01-F-6  
Fed. + Education  
Improv.  
Waynflete  
Campus  
Waynflete  
School

Waynflete Loop Road Improvements

PUBLIC WORKS ENGINEERING REVIEW..5/09/03

PUBLIC WORKS ENGINEERING REVIEW...5/16/03

TITLE
**LAYOUT &
 MATERIALS PLAN**

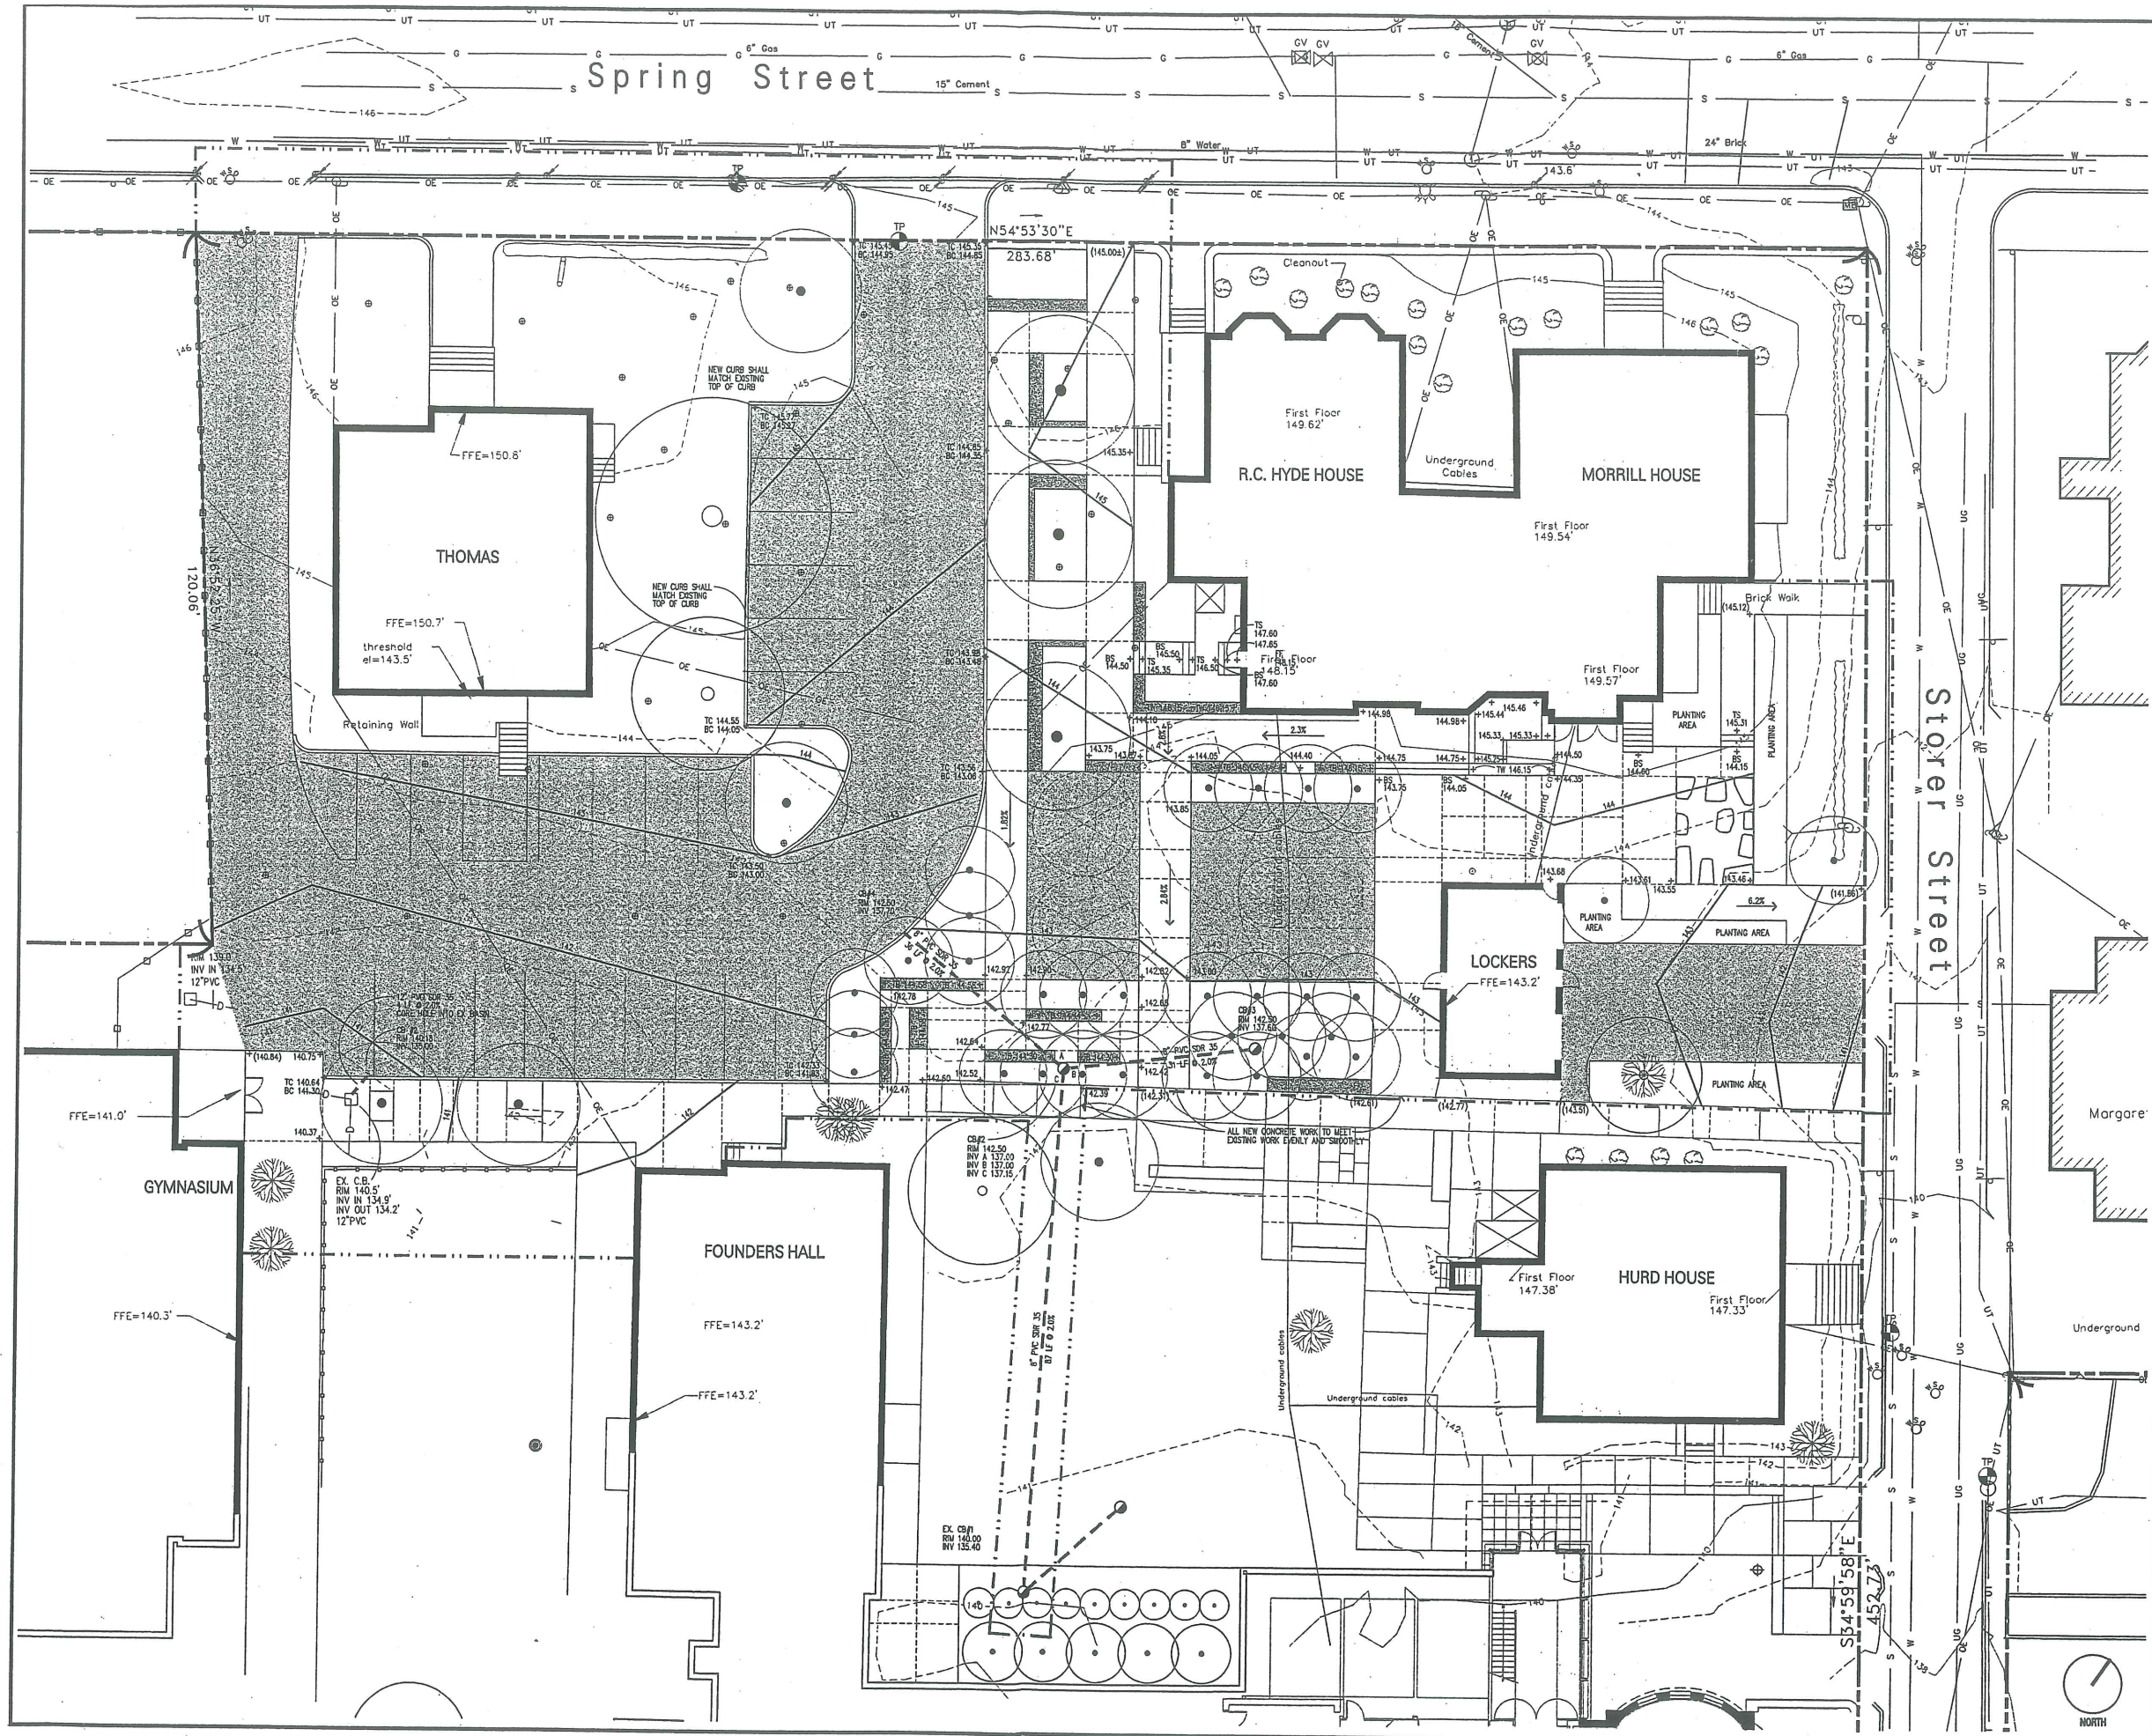
1. The applicant proposes to close some curb cuts on Spring and create a new. As such, the applicant will need to install new granite curb or recycle the existing as much as possible. The plan set needs to specify if new curb will be installed or a combination of installing new/recycled curb.

2. The plans need specify the proposed limits of excavation in Spring Street related to the new curb cut, closing of existing curb cuts, curb installation, and new brick sidewalk construction.

3. According to the City's Sidewalk Materials Policy, sidewalk must remain brick and the plans need to identify the limits of any sidewalk repair associated with this development. The "policy" also requires that within the public right of way, the new driveway apron must be constructed of brick. This needs to be specified on the plans.

In order to soften the appearance of the school from the street and to strengthen the residential character of Spring Street between the Hyde and Thomas Houses, I request that up to four additional street trees be installed along the Spring Street frontage of the school.
